Deadline 5 – Response to ExQ2

Project: Norwich to Tilbury Electricity Transmission Project (EN020027)

Interested Party: Caroline Homewood – Ford Street, Aldham and Fordham in Colne Valley

National Grid's Failure to Address the Examining Authority's Questions Regarding the Colne Valley

**Appendix E
Action Point 27 –
Colne Valley
(including Fordham,
Ford Street, Aldham)
Constraints and
Opportunities Plans**

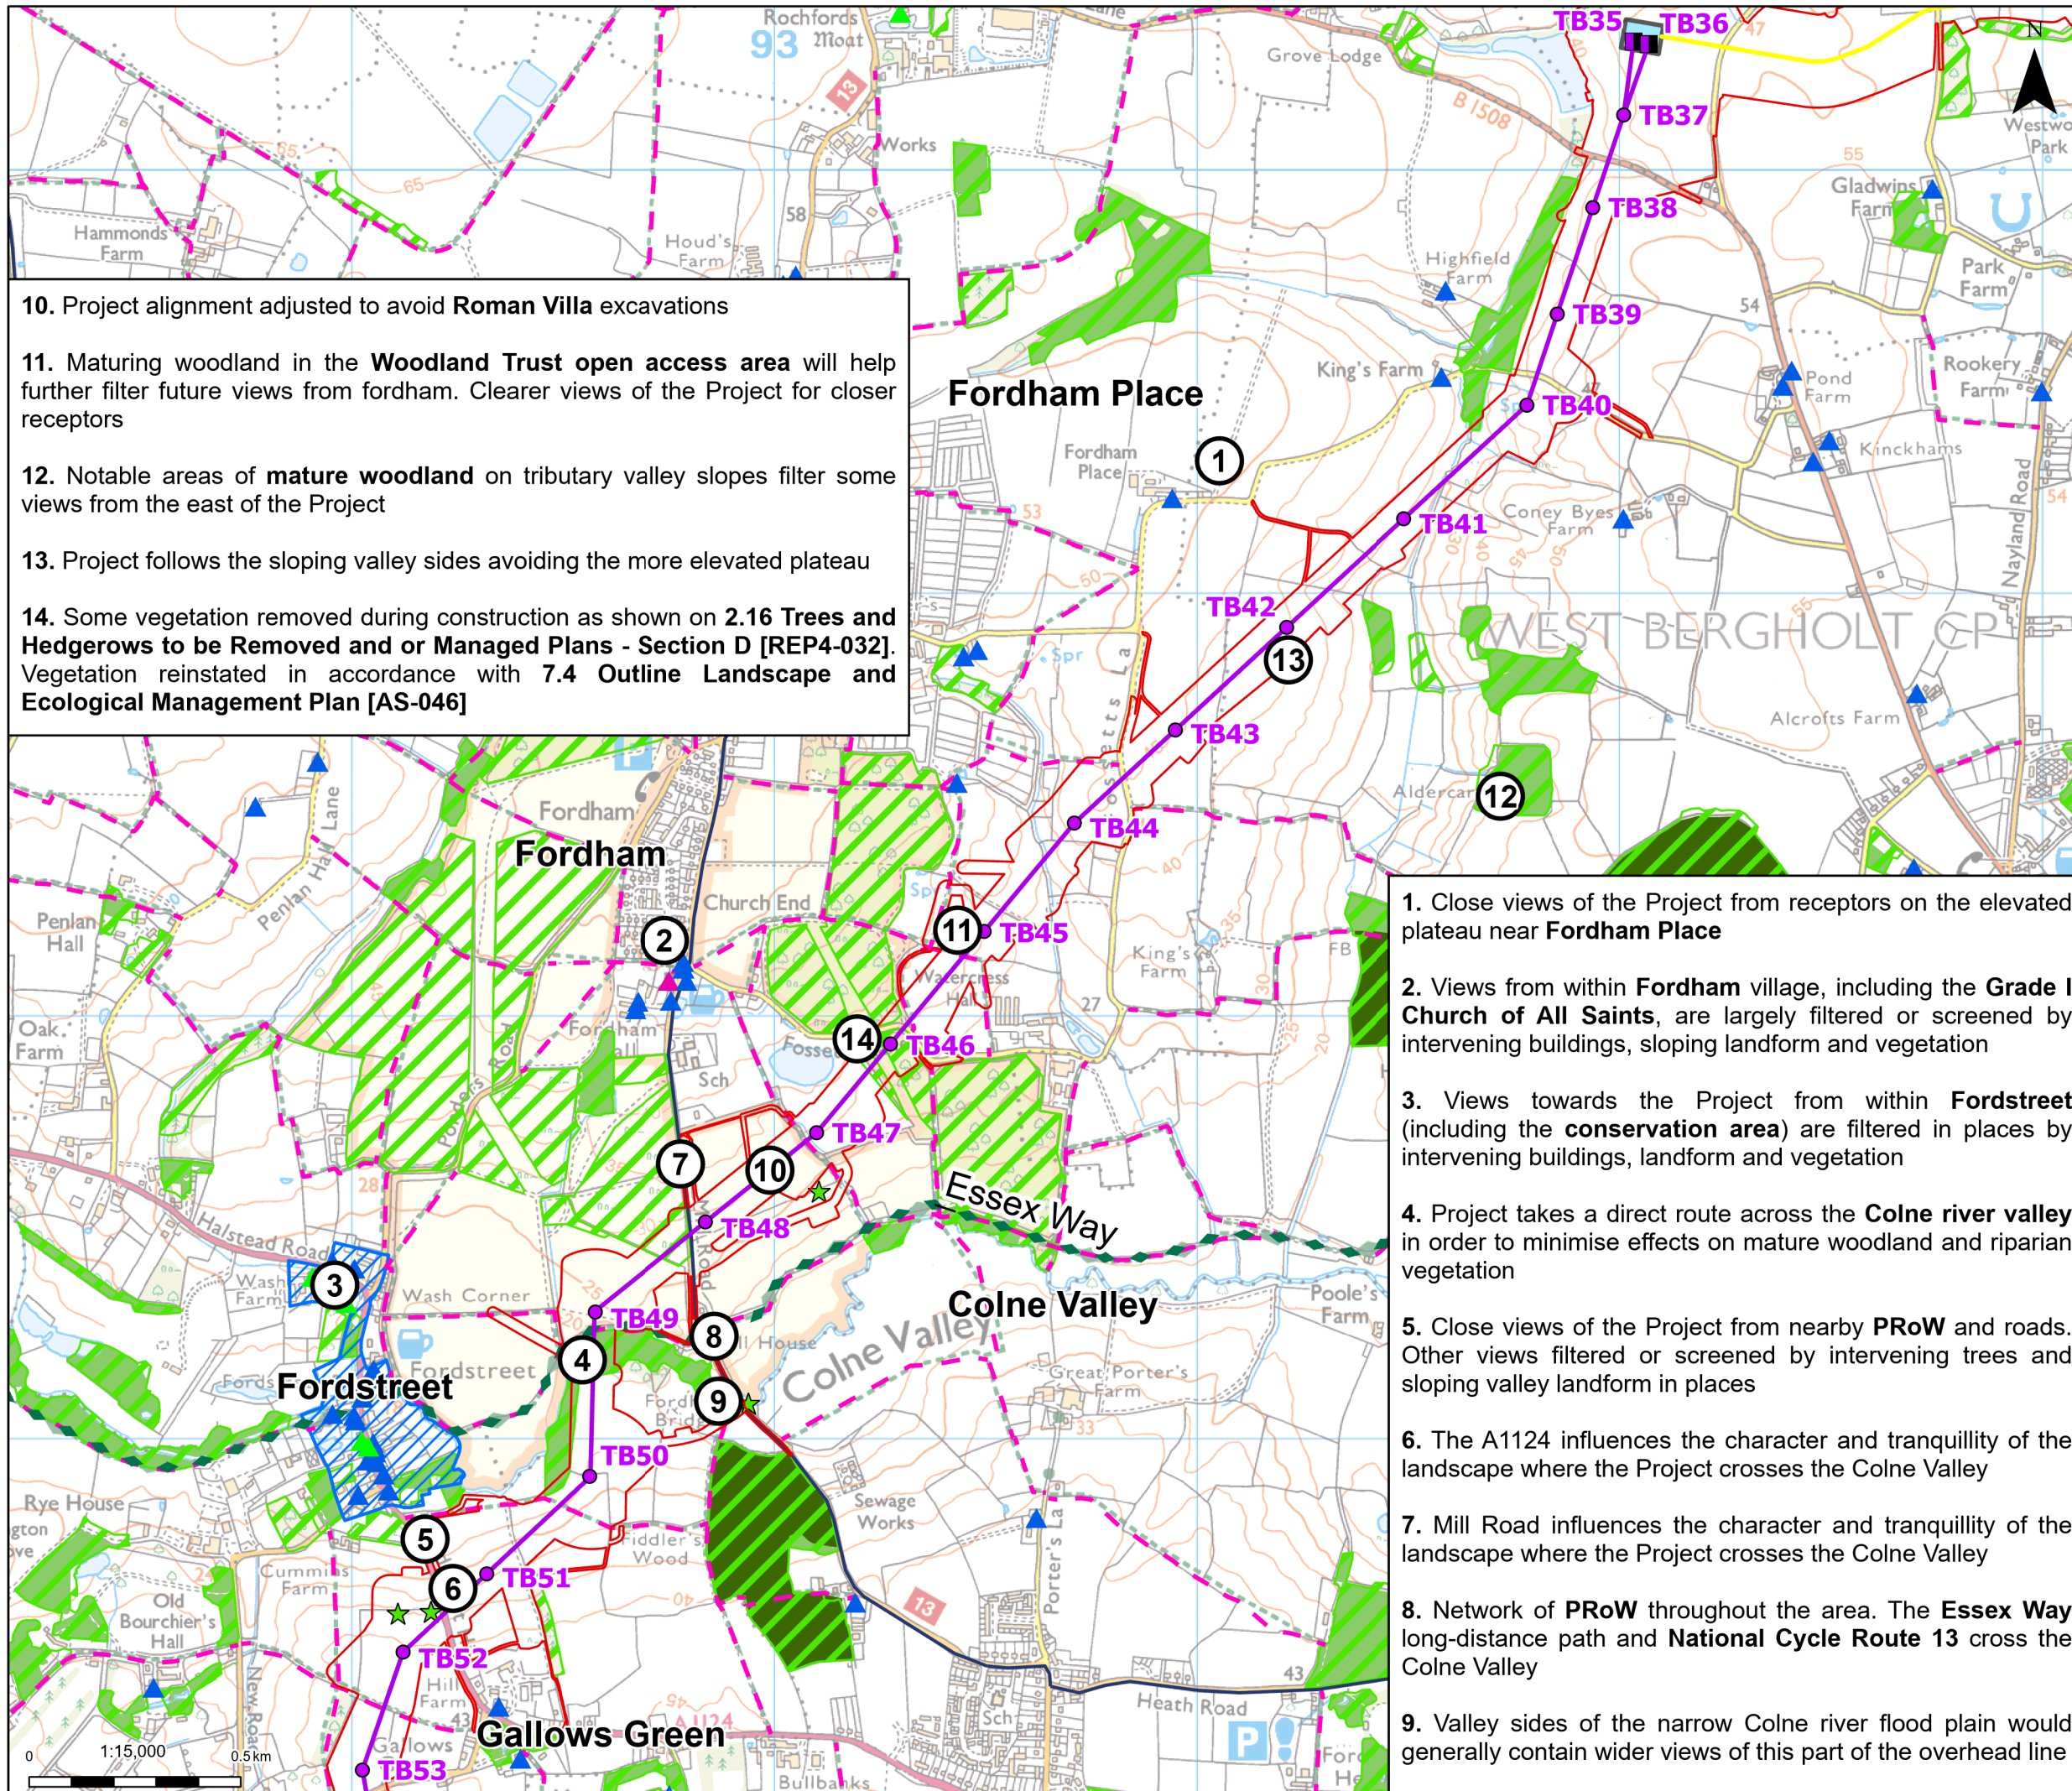
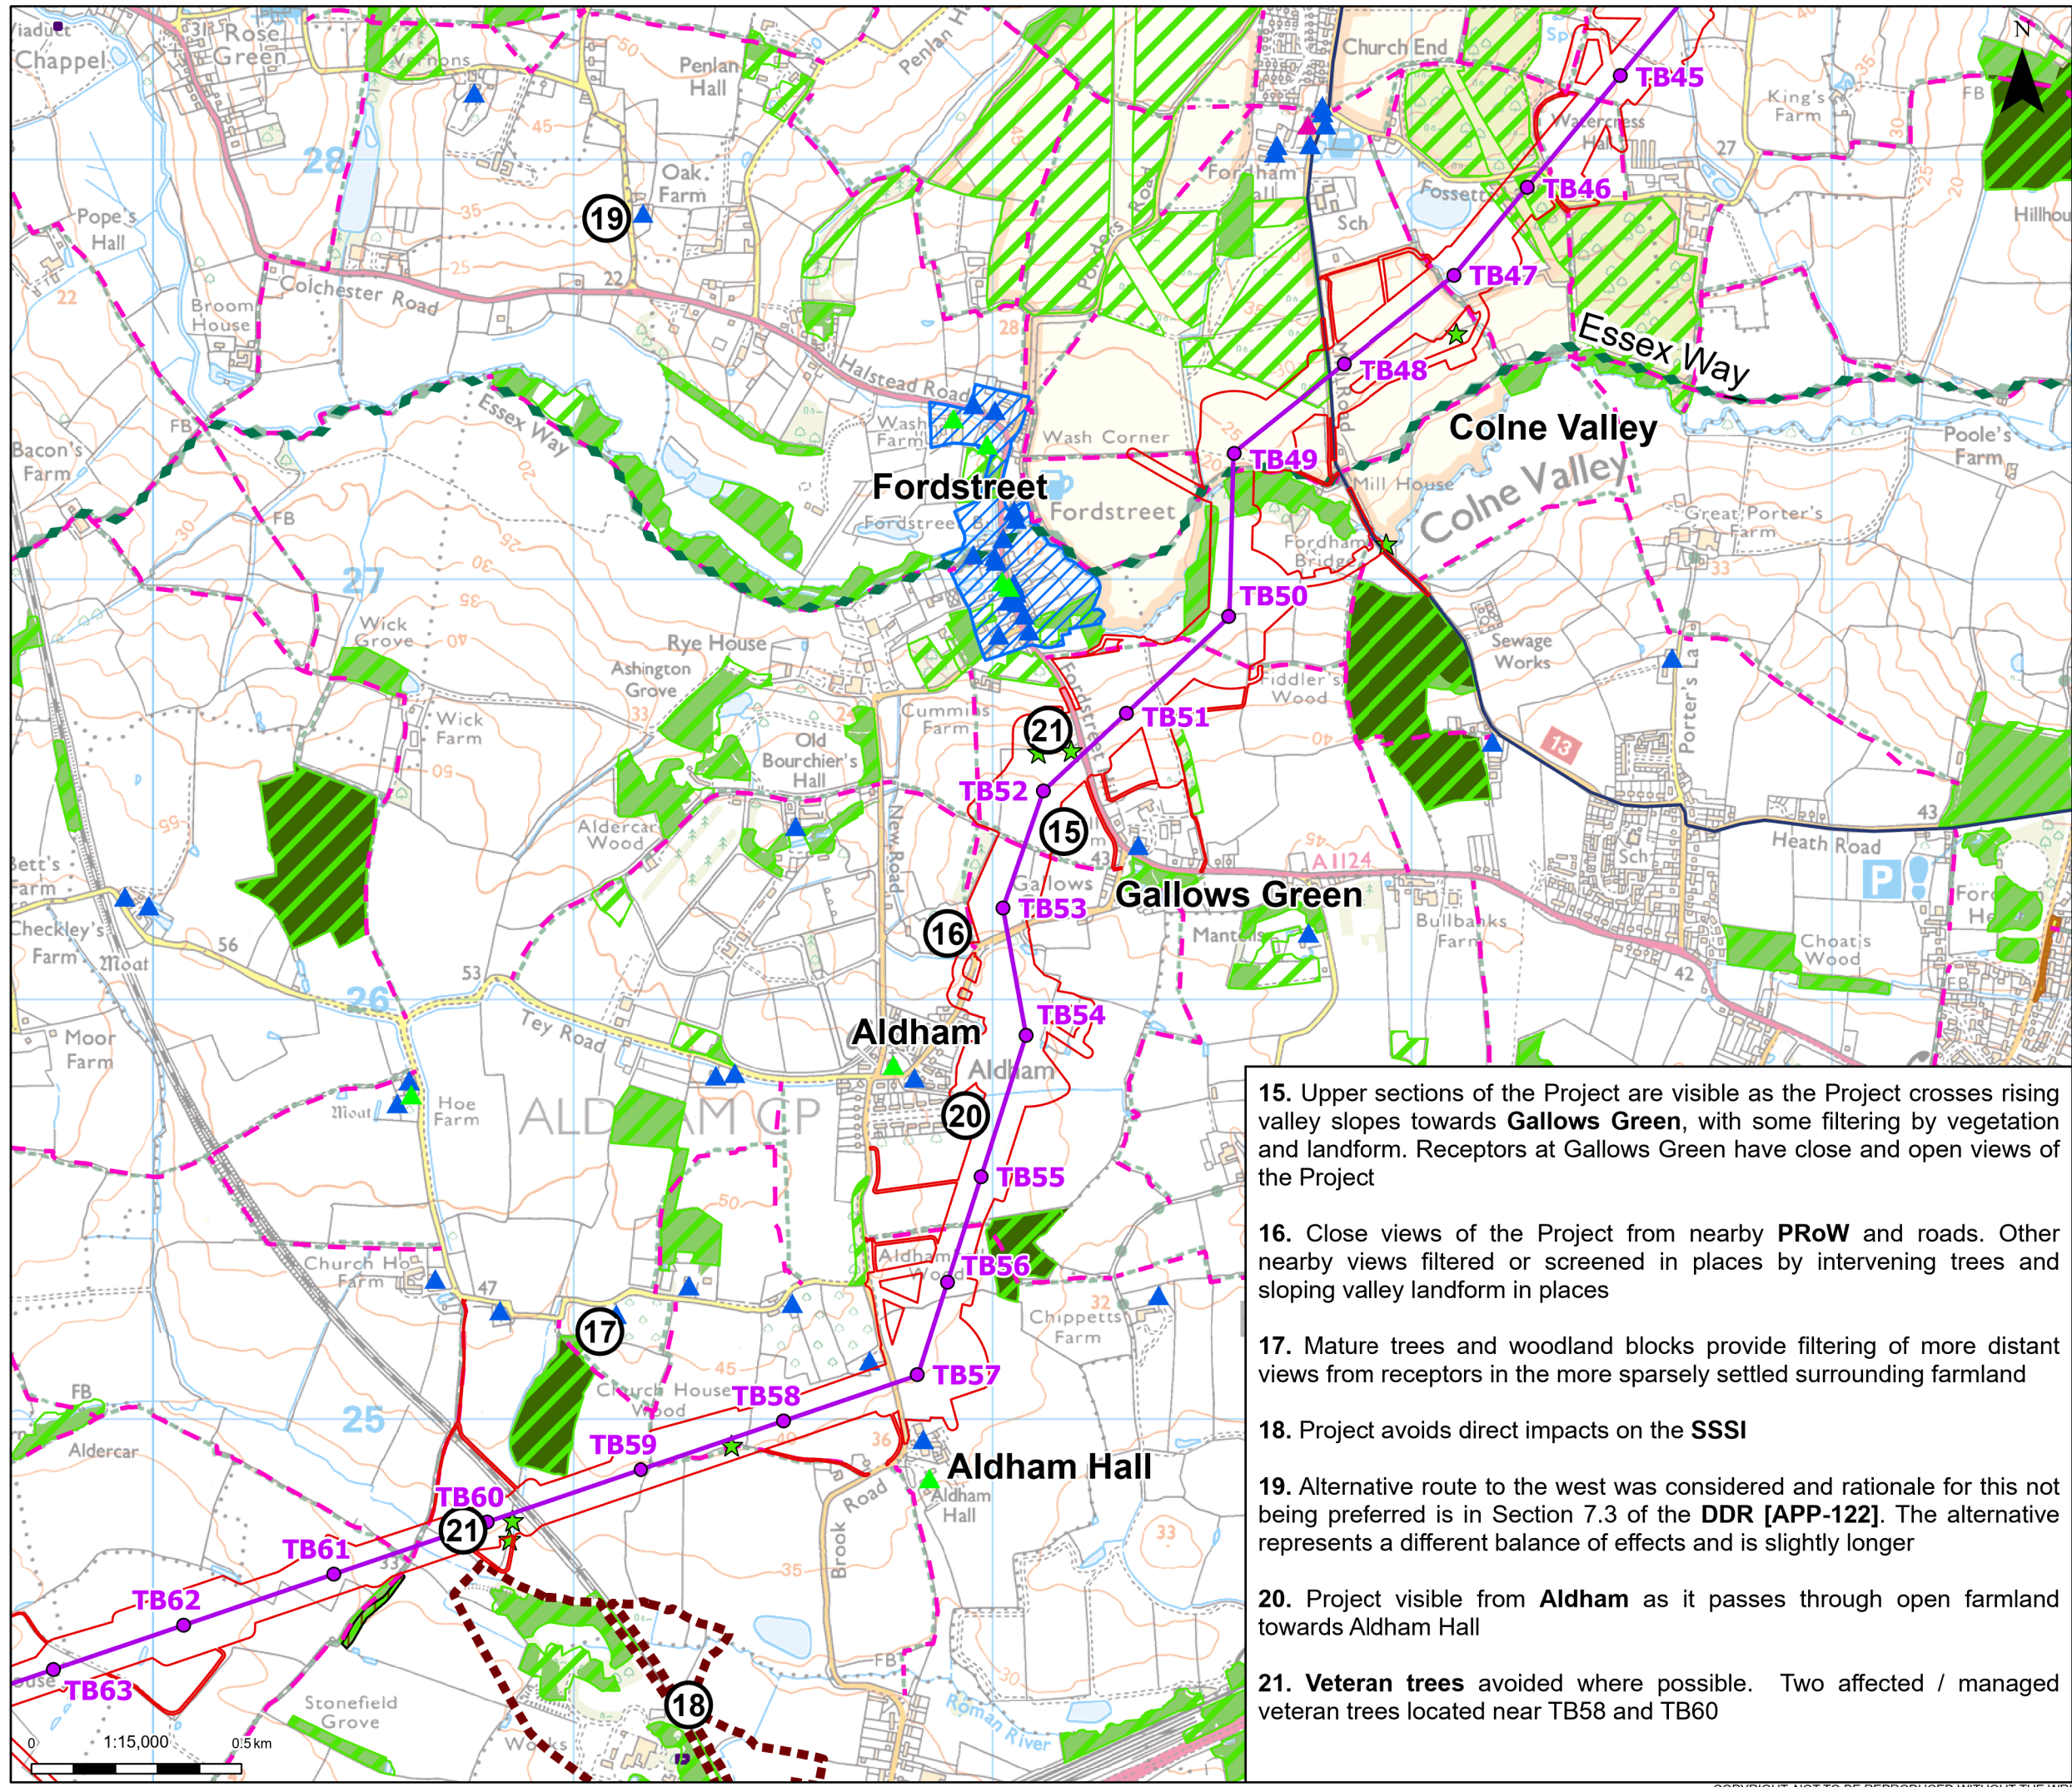
The Examining Authority specifically requested coordinated masterplans for the Colne Valley incorporating:

- landscape;
- ecology;
- archaeology;
- rights of way; and
- built heritage.

The Examining Authority was not asking for a further description of individual constraints. It was seeking an explanation of how those constraints interact and whether their cumulative significance had been properly assessed.

However, National Grid's response to ISH2 Action Point 34 does not provide such an assessment. Instead, the Applicant describes topography, woodland, archaeology, heritage assets, floodplain constraints and residential receptors individually before concluding that alternative routes would merely represent a transfer of effects elsewhere.

That response does not address the question posed by the Examining Authority. It merely repeats route selection conclusions already contained within the Design Development Reports. The concern regarding cumulative effects therefore remains unresolved.
